Our Ref: SDNP/18/02230/ADJAUT
Contact Officer: Vicki Colwell
Tel. No.: 01730 819280

18th May 2018

Neighbouring Authority Consultation

**Proposal: A/36/18/OUT - Outline planning application with some matters reserved for the erection of up to 200 dwellings with access, public open space, landscaping and sustainable drainage system (SuDS) with vehicular access point from Arundel Road, one full-sized adult football pitch and the demolition of industrial units and one residential dwelling. Departure from the Development Plan.
Address: Land Off Arundel Road, Angmering, BN16 4ET**

Figure 5.2: Illustrative Masterplan.

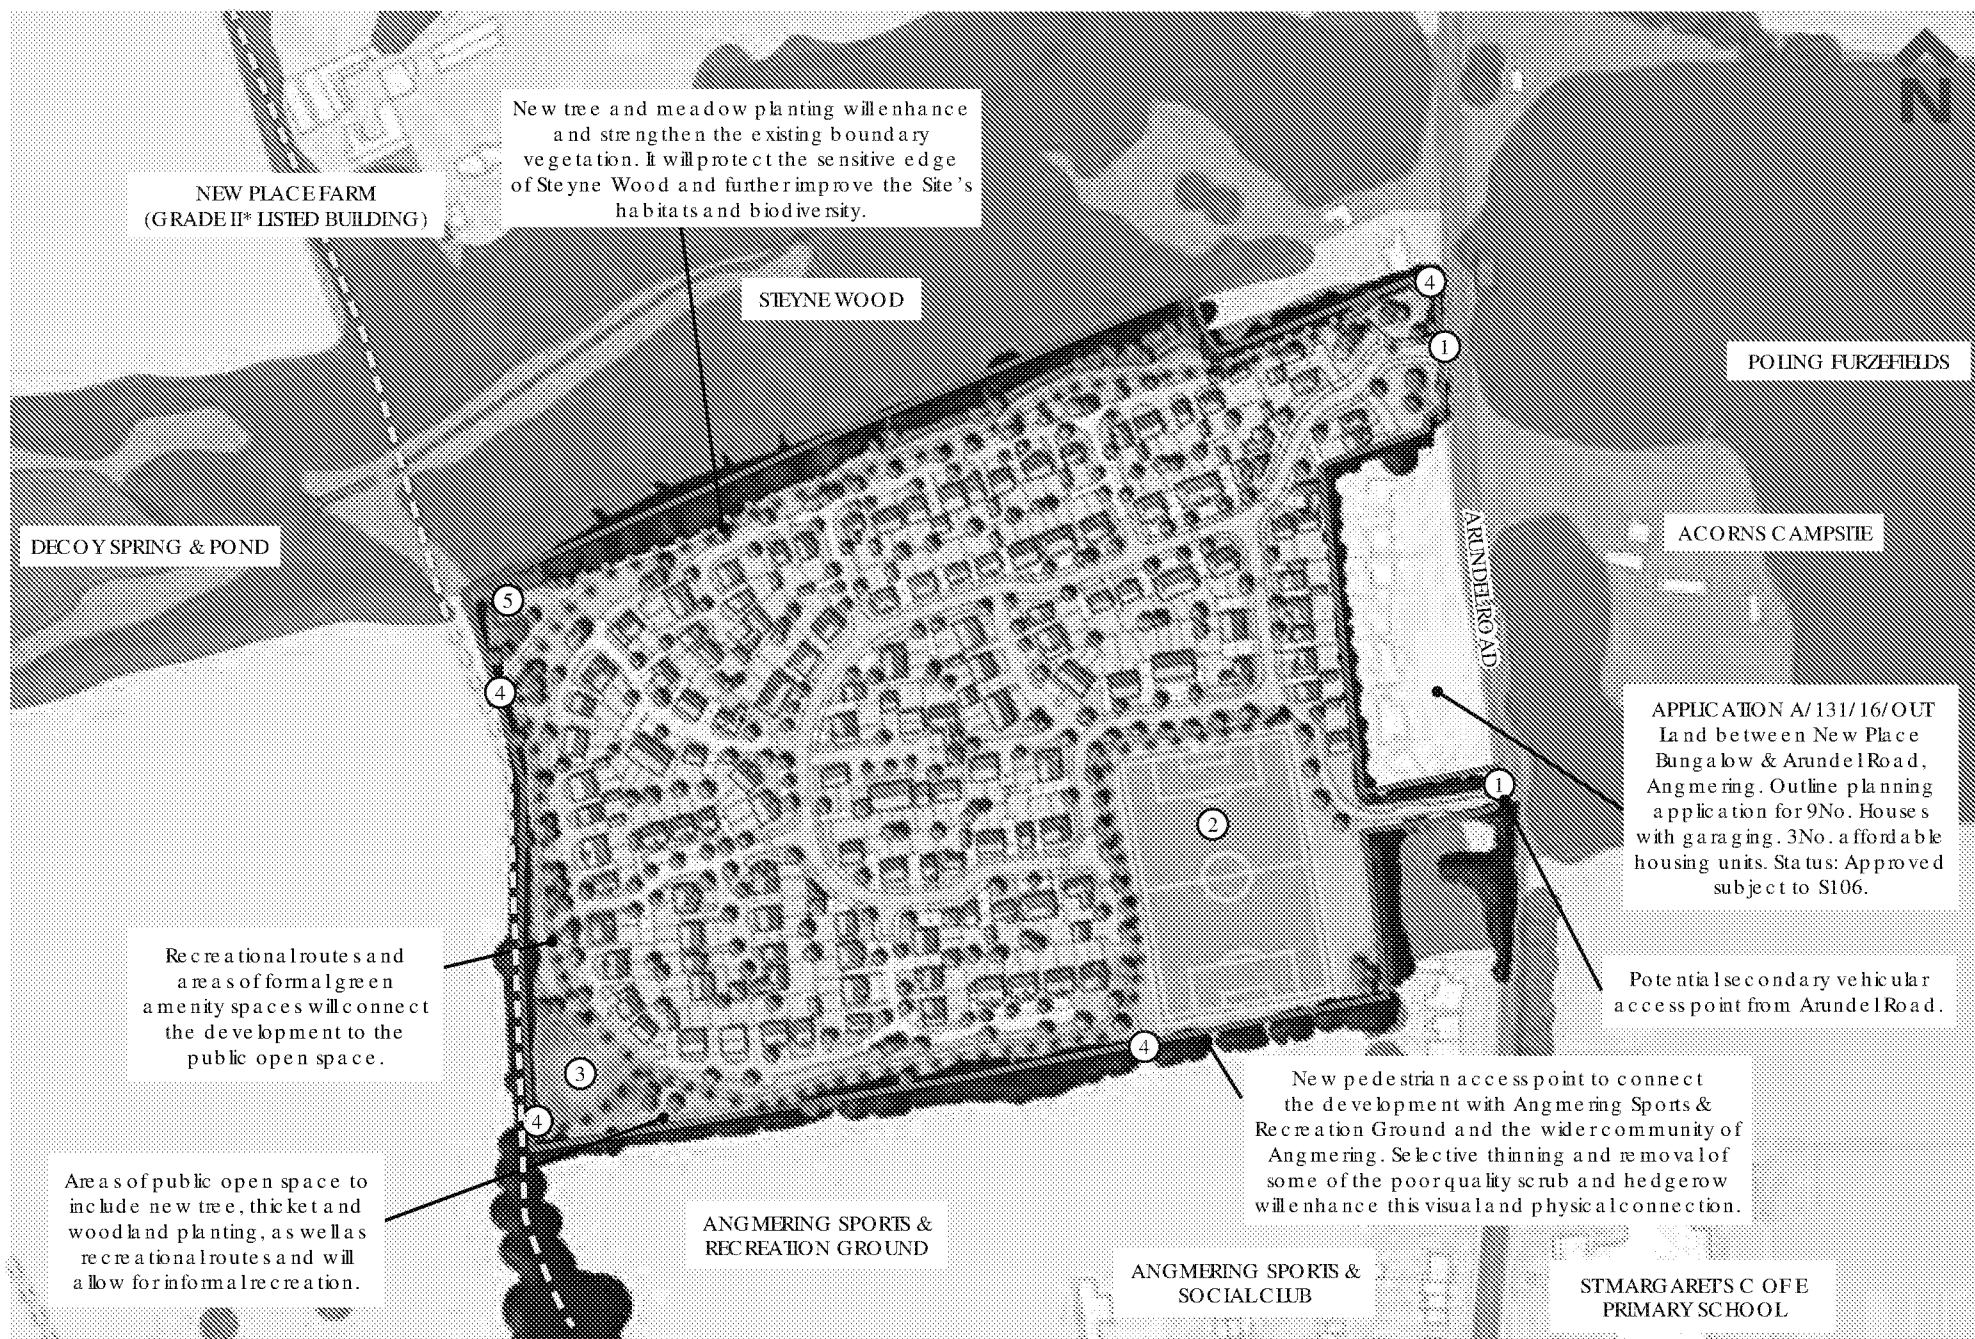
The masterplan includes a narrow stretch of open space around the perimeter of the site. It is not integrated into the layout of the scheme and does little to connect existing areas of habitat, particularly the surrounding woodland. As currently proposed it has the potential to merely form a circuit for dog walkers and is unlikely to be particularly inviting or an asset for more than the immediate residents. In many

places it may be too narrow to provide any opportunities for ecological enhancement.

Due to the proximity of the SDNP, we would also encourage the developers to rethink the open space integrating it with the landscape and changes in contours as well as making linkages to the adjoining habitats, particularly the woodland. This is an opportunity to bring the National Park to the existing and new residents of Angmering.

The proposed full sized adult football pitch is unlikely to form a focal point and may need to be accompanied by fencing, lighting, changing facilities and parking to be used to its maximum potential. This needs to be considered in the design of a scheme. The close proximity of new homes to the pitch is likely to lead to conflict.

Figure 5.4: Proposed main vehicular access point off Arundel Road.

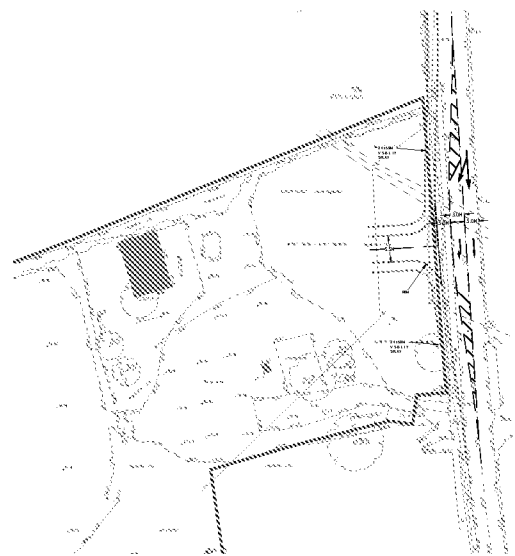
Providing direct access from the site to Arundel Road and the footpath to the west is supported but must be accompanied by measures to upgrade the pedestrian facilities and linked footpaths beyond for NMU and reduce the impact of traffic on it. In addition signage within the development site should also be provided to highlight where these links exist.

Any new or upgraded infrastructure should be accessible to the largest possible range of users and therefore be designed to take into account the needs of walkers, cyclists, horse riders and people with disabilities.
